July 19, 2021

**Re: Tree Planting Recommendations  
Klondike Ridge-Block 10  
1055 Klondike Road  
Ottawa, Ontario**

A preliminary grading plan titled: "Grading Plan, Klondike Ridge-Block 10, Drawing No. 117034-10-GR" was provided to us by Novatech for review. The City of Ottawa document titled "Tree Planting in Sensitive Marine Soils-2017 Guidelines, Draft Version 2.0", dated January 7, 2019 was referenced for our review as well as the above mentioned reports and memorandums prepared by GEMTEC.

PROJECT No: 117034-10
REV: 1
DRAWING No: 117034-10-GR

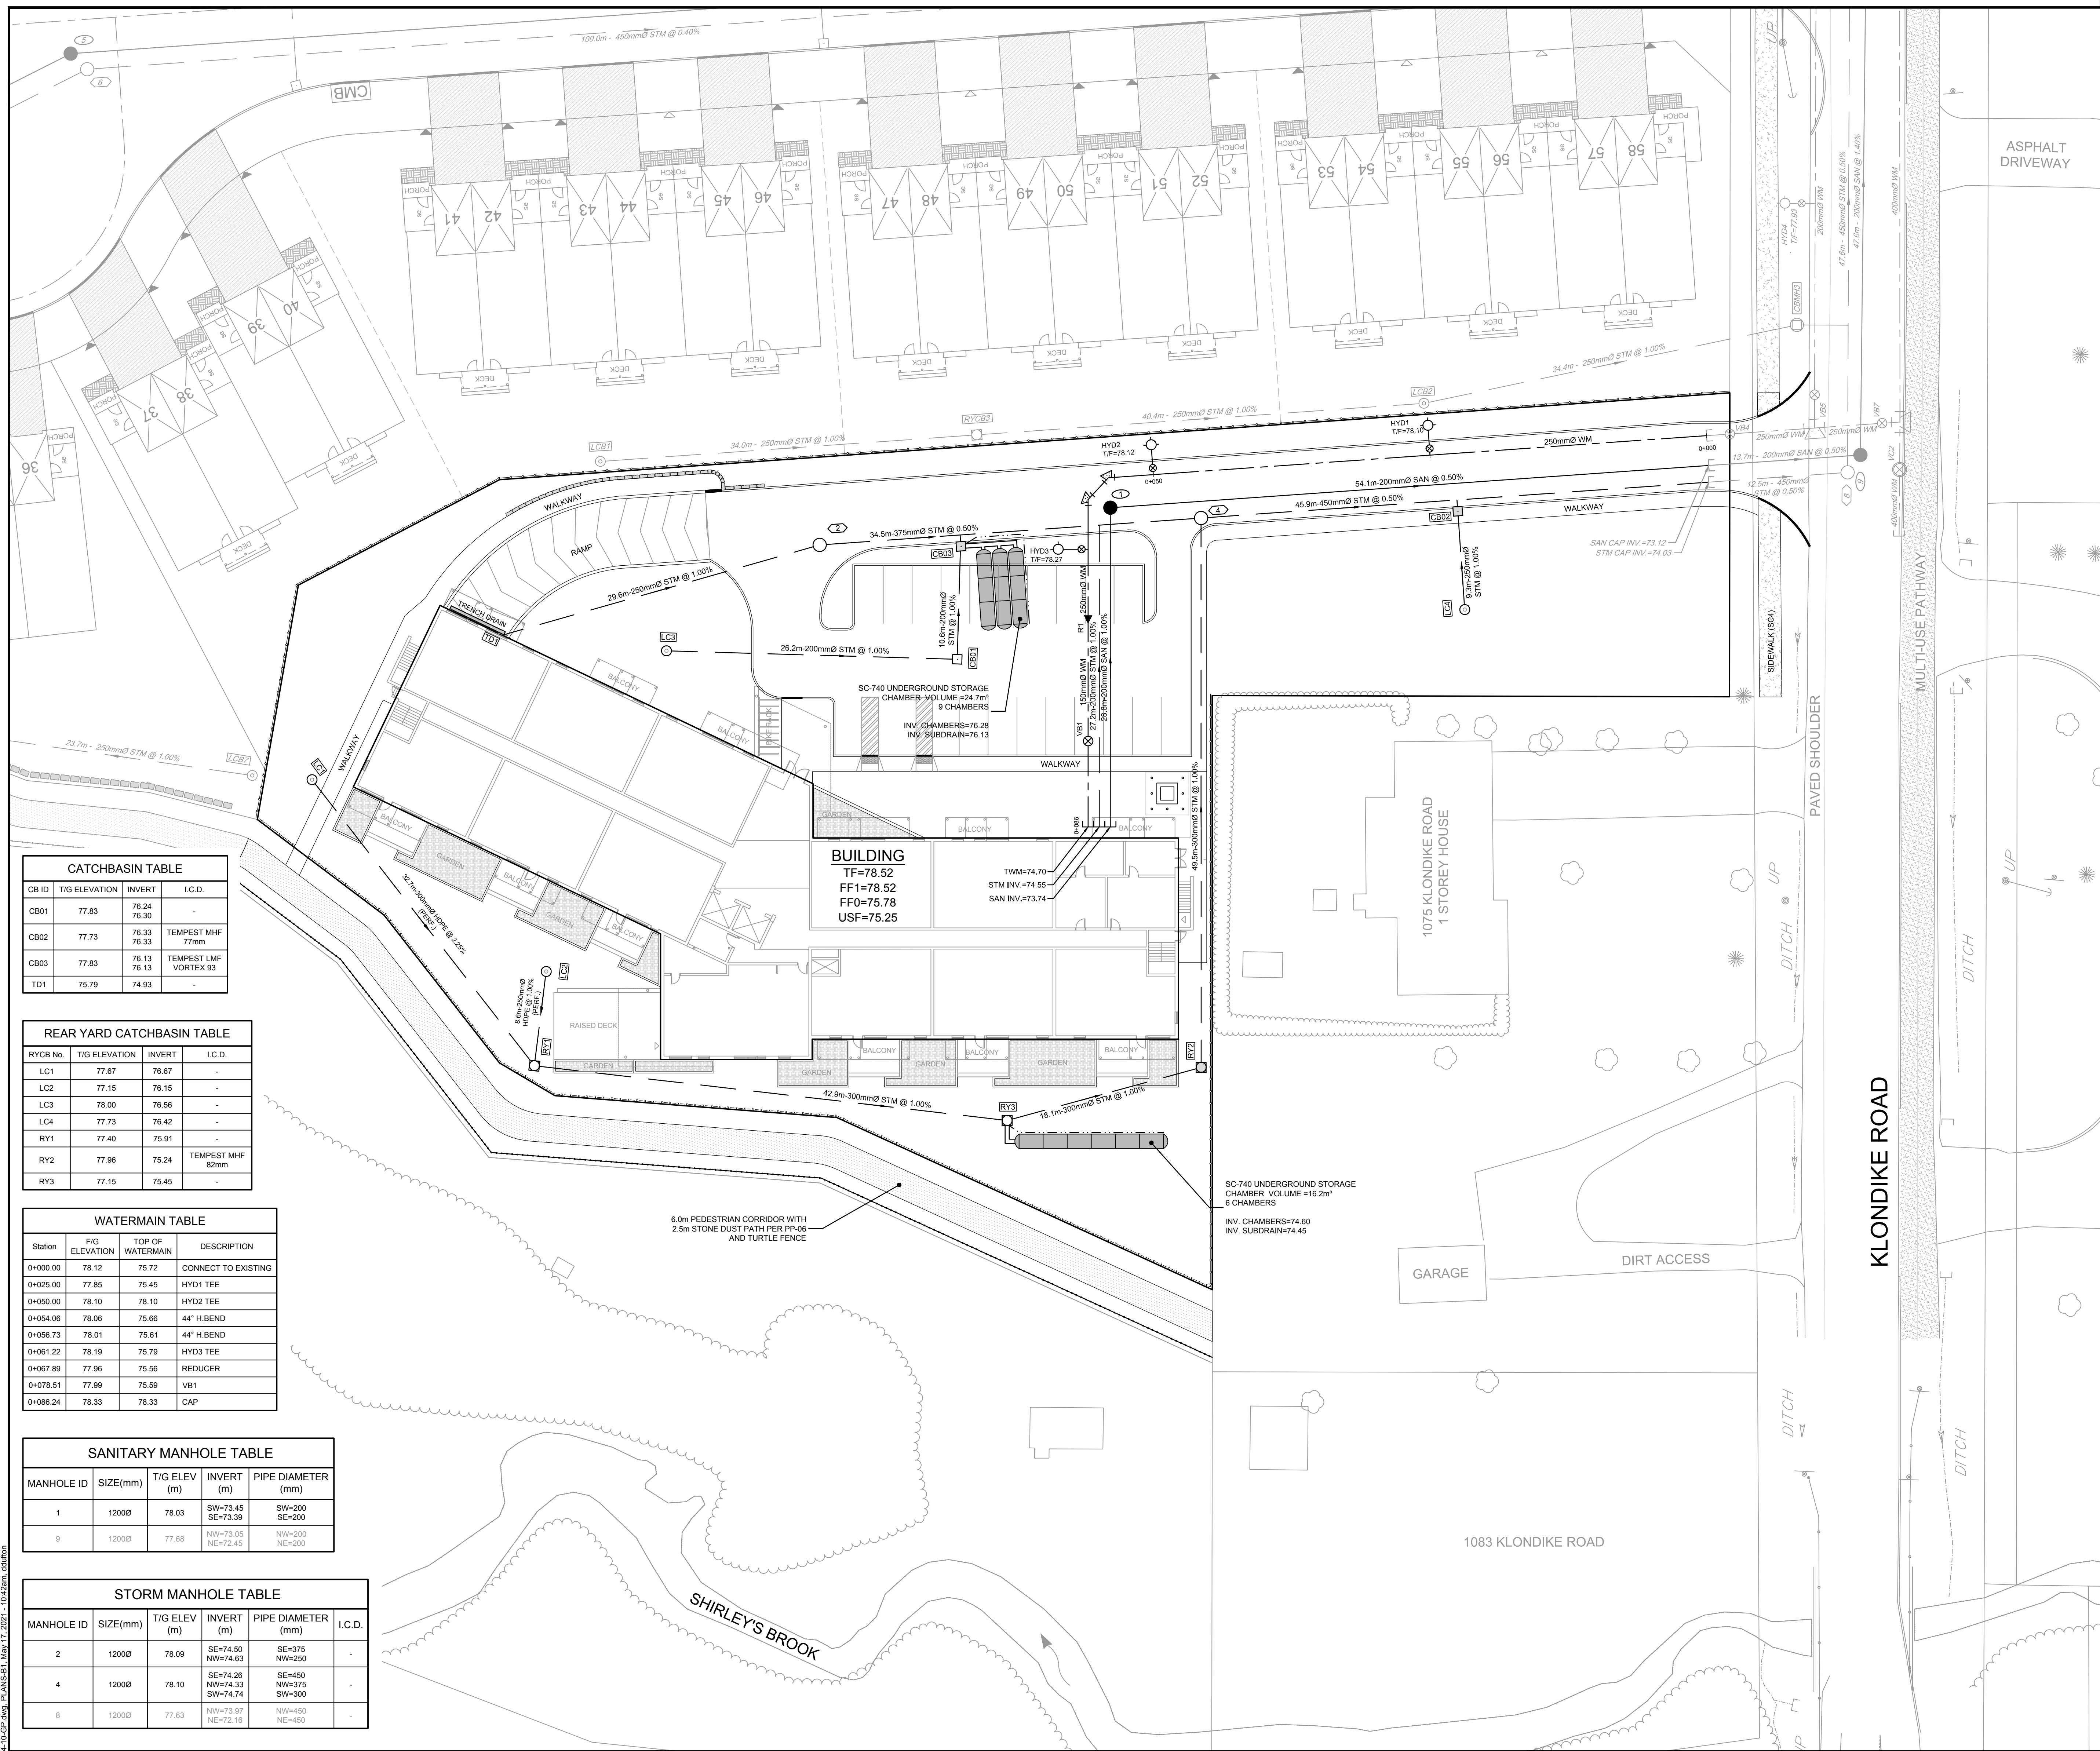
Based on a review of the grading plan provided, the finished grades of the proposed apartment building meet this requirement.

*Grading surrounding the tree must promote draining to the tree root zone (in such a manner as not to be detrimental to the tree), as noted on the subdivision Grading Plan and detailed on the Landscape Plan.*

It is recommended that the above comment be reflected on the Grading and Landscape plans.
